STATE OF NORTH CAROLINA
DEPARTMENT OF TRANSPORTATION

Addendum No. 1

RE: Contract # C204703

I-85 FROM NC-109 IN THOMASVILLE TO SR-1009 (SOUTH MAIN STREET) IN ARCHDALE.

PROJECT NO.	SHEET NO.	TOTAL NO.
49637.3.1 (HI-0002)	3A-2

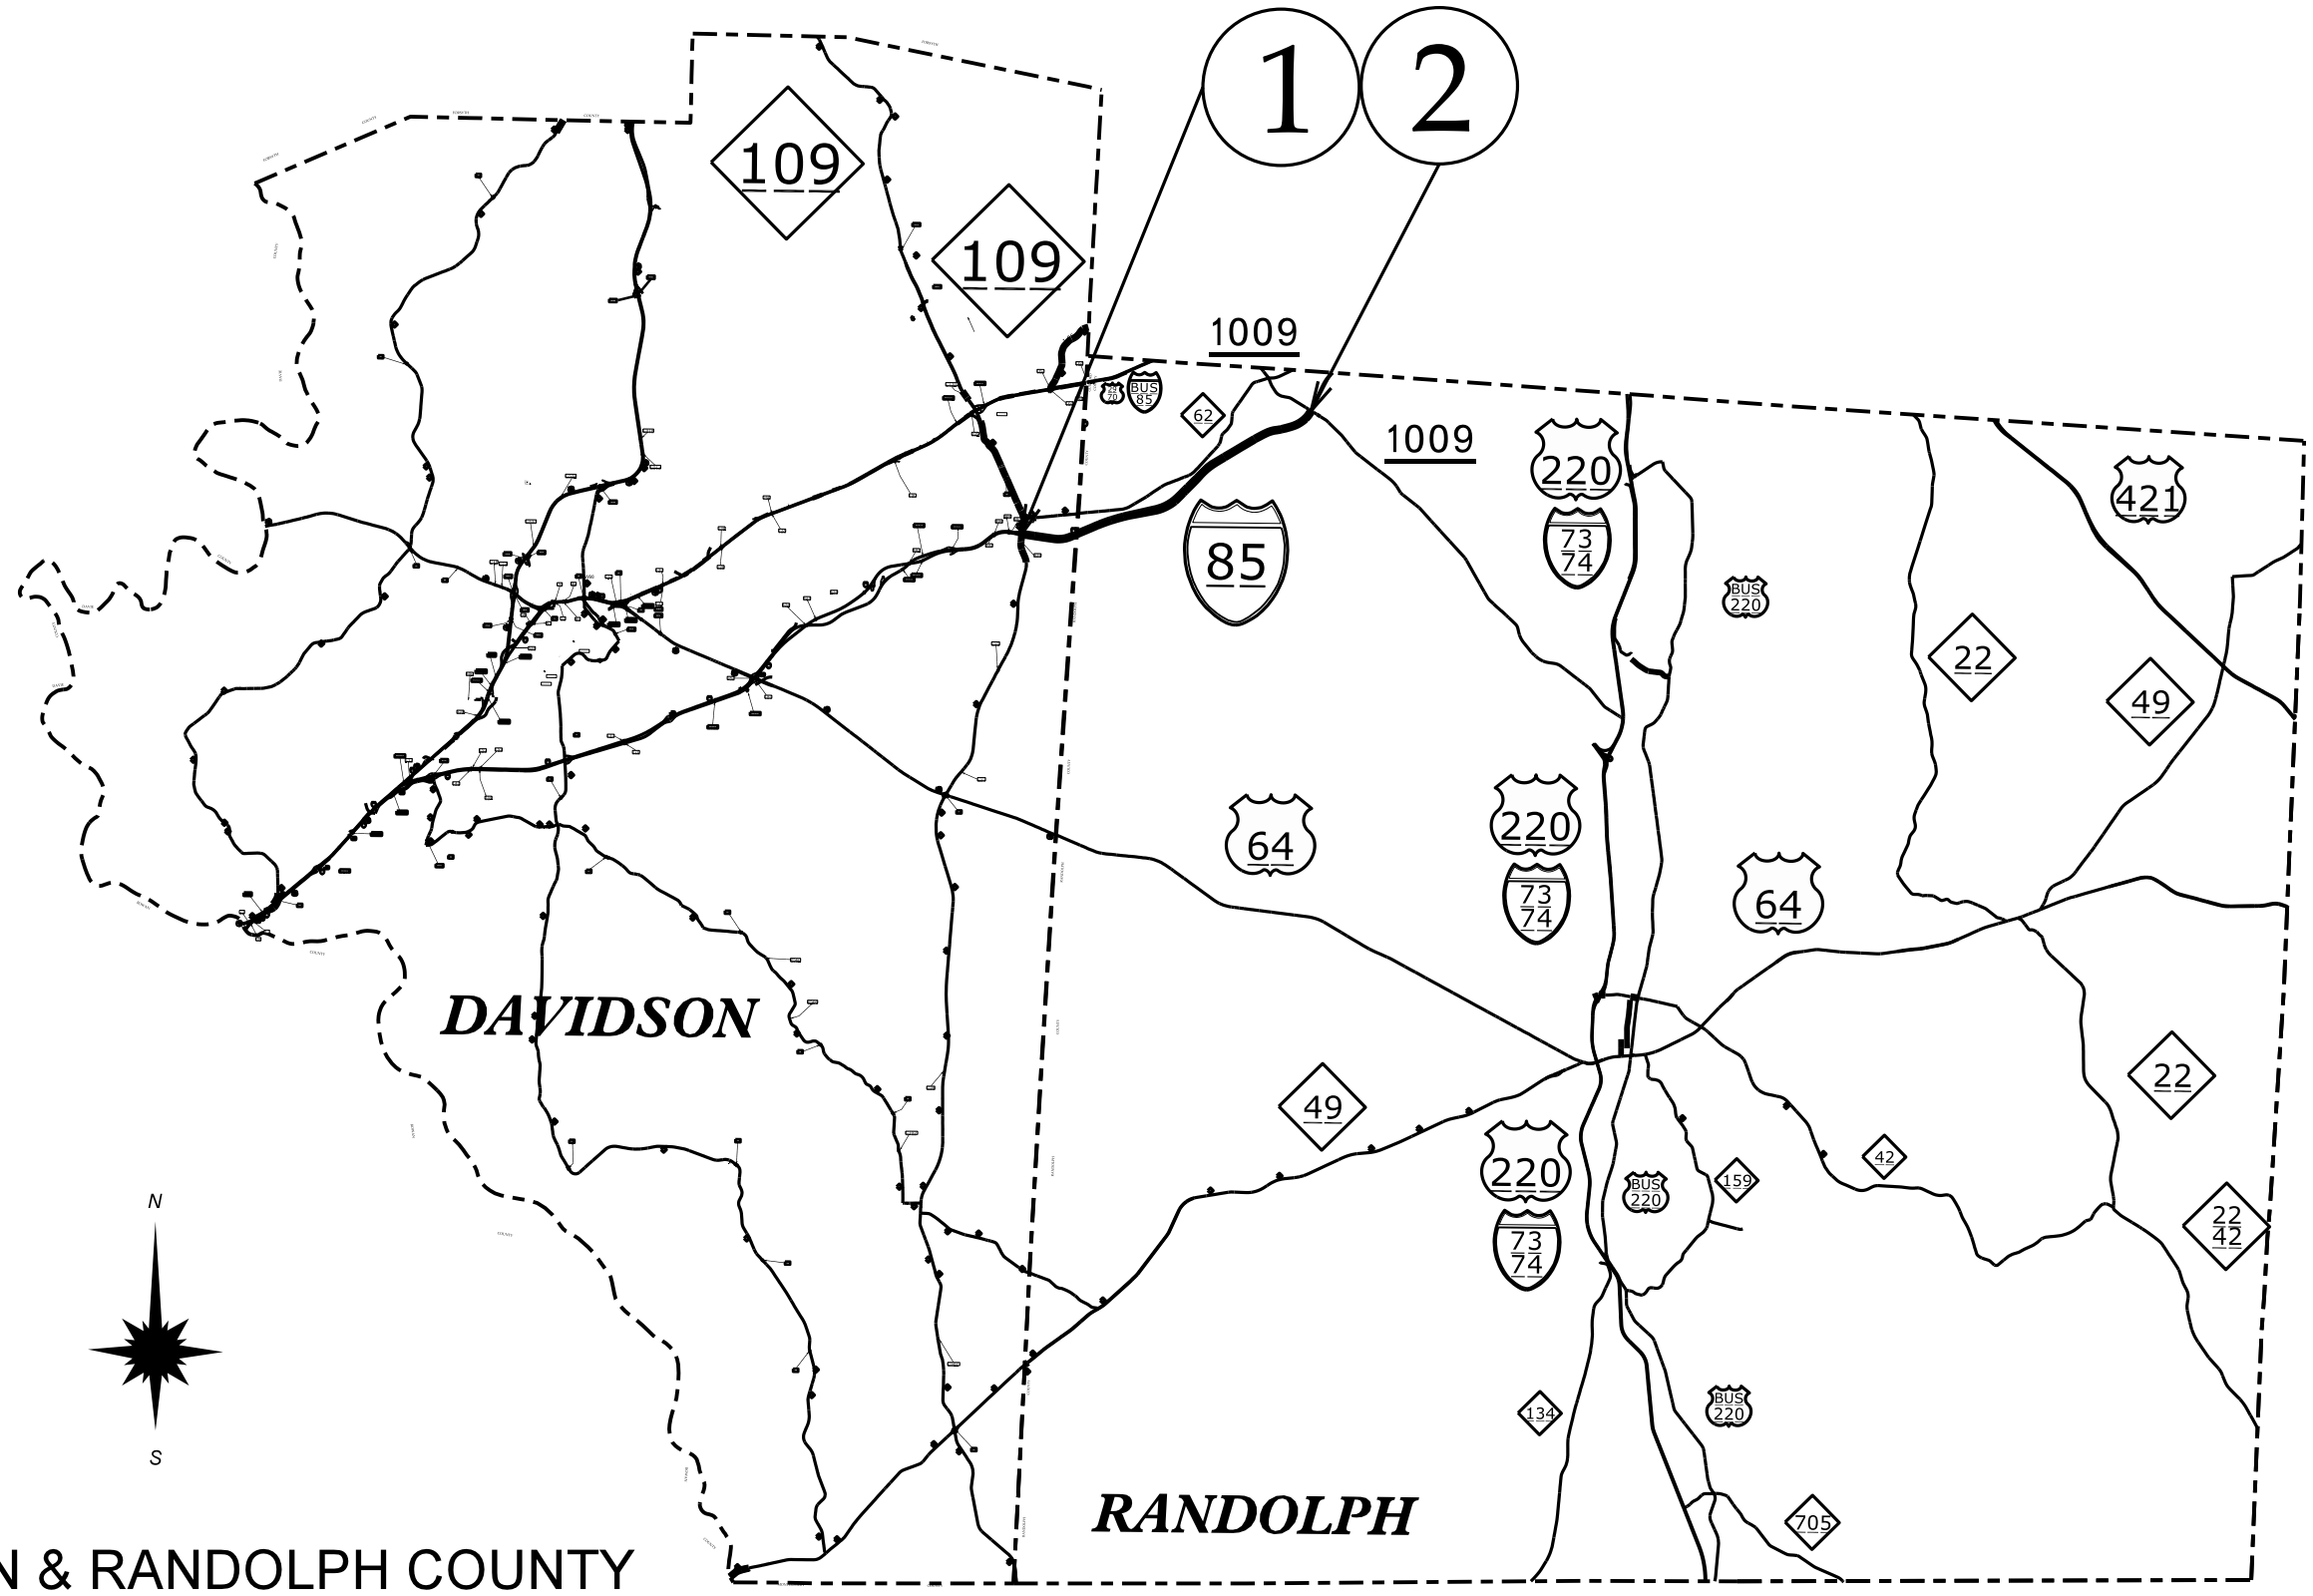
Sheet No.	Revision
3A-1, 3A-2	Summary of Quantities updated.
4	Location Maps updated.
5-8 (New)	Location Maps updated.

Please void the above listed Sheets in your plans and staple the revised Sheets thereto. Staple New Sheets 5-8 after revised Sheet 4 in your plans.
